Recommendation Report for Planning Permission

REF NO: BR/147/20/PL

LOCATION: 53 High Street
Bognor Regis
PO21 1RX

PROPOSAL: Conversion of first & second floor & rear extension to create 4 No. 1-bed self--contained flats including the demolition of existing rear extension & erection of two storey rear extension. This application may affect the setting of a listed building & may affect the character & appearance of The Steyne, Bognor Regis Conservation Area. This application is in Cil Zone 4 (Zero Rated) as flats.

Drawing
Proposed Front and Rear
Elevations

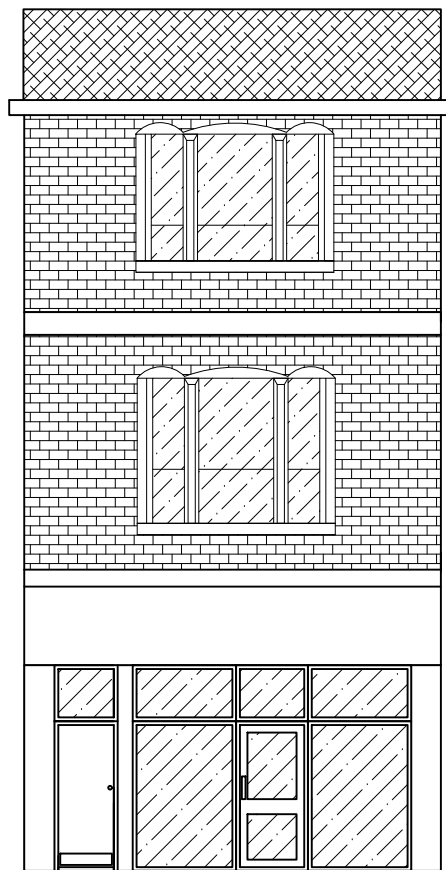
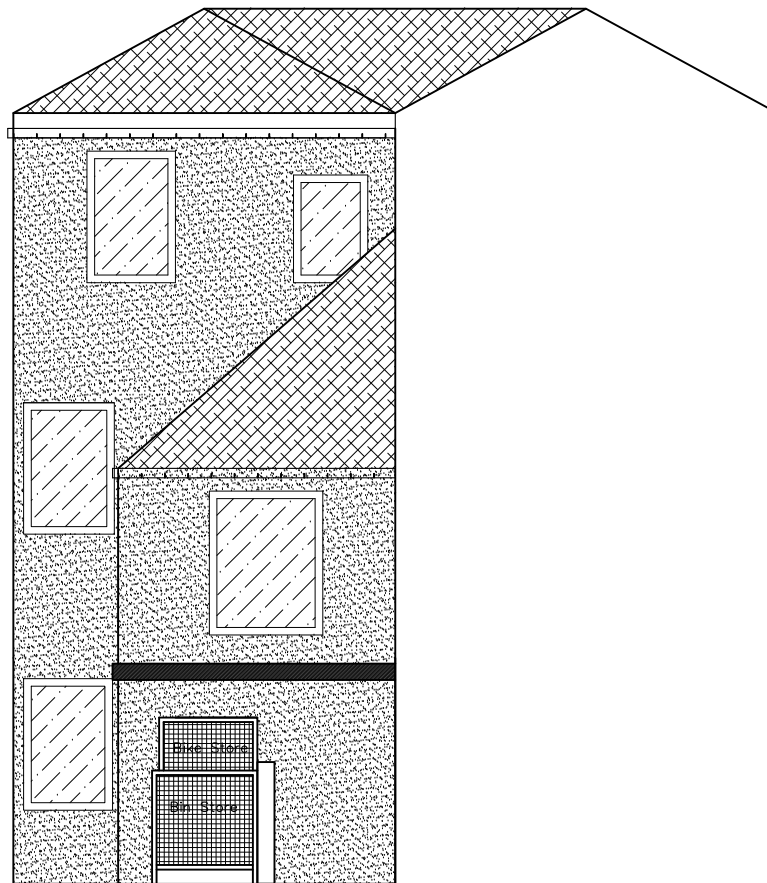
supported, and it is suggested that the two string course items should also remain. The replacement shop front will be of aluminium construction, which is unfortunate.

It is regretted that the renovated shop frontage will be aluminium powder coated and not pick up the style and materials of the original building but there are other similar shop frontages close by and the panel cannot see that this will sway planning officers.

The shop front design has been amended to wooden.

Comments noted. The applicant/agent followed the advice of Conservation Officer and Conservation Panel and amended drawings replacing proposed aluminium construction of shopfront with a timber framed.
